From: [Bryan Bobrick](#)
To: [Harmon Rita T.](#)
Subject: Re: FW: Following up from Friday regarding Penguin Chill plans
Date: Friday, October 07, 2016 11:33:42 AM
Attachments: [image001.png](#)

Please see the attached approval letter from Hydrology, pending a condition that WUA will accept the drainage from the trench drains.

CG-102
SHEET OF

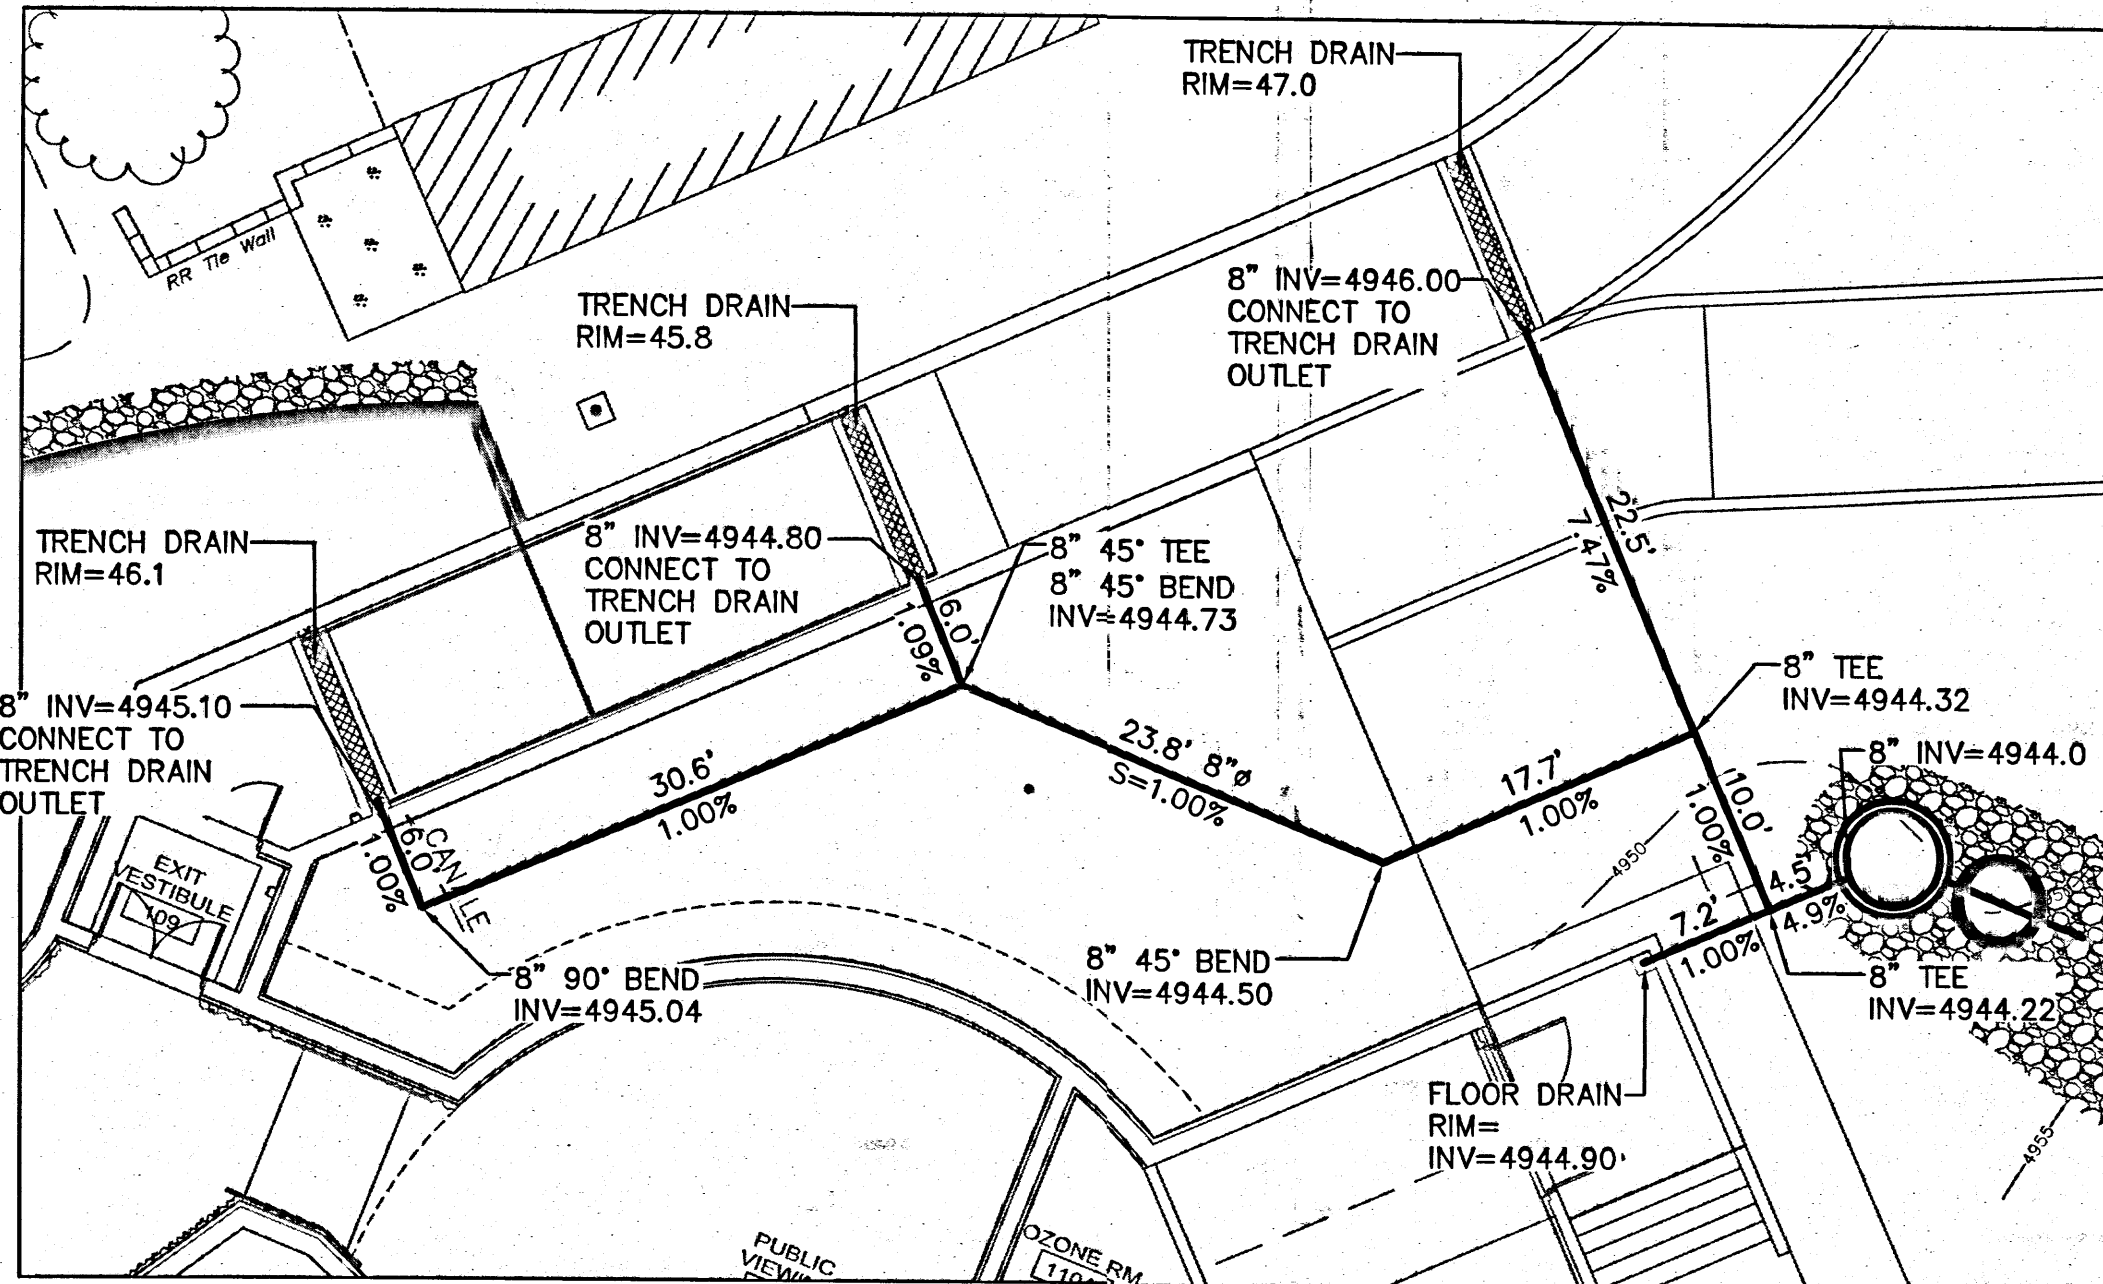
Additionally, the Building Permit process will be complicated if the retaining walls are shown partially on the architectural plans, and partially on the Civil plans. It would be better to show all retaining walls on the Civil plans.
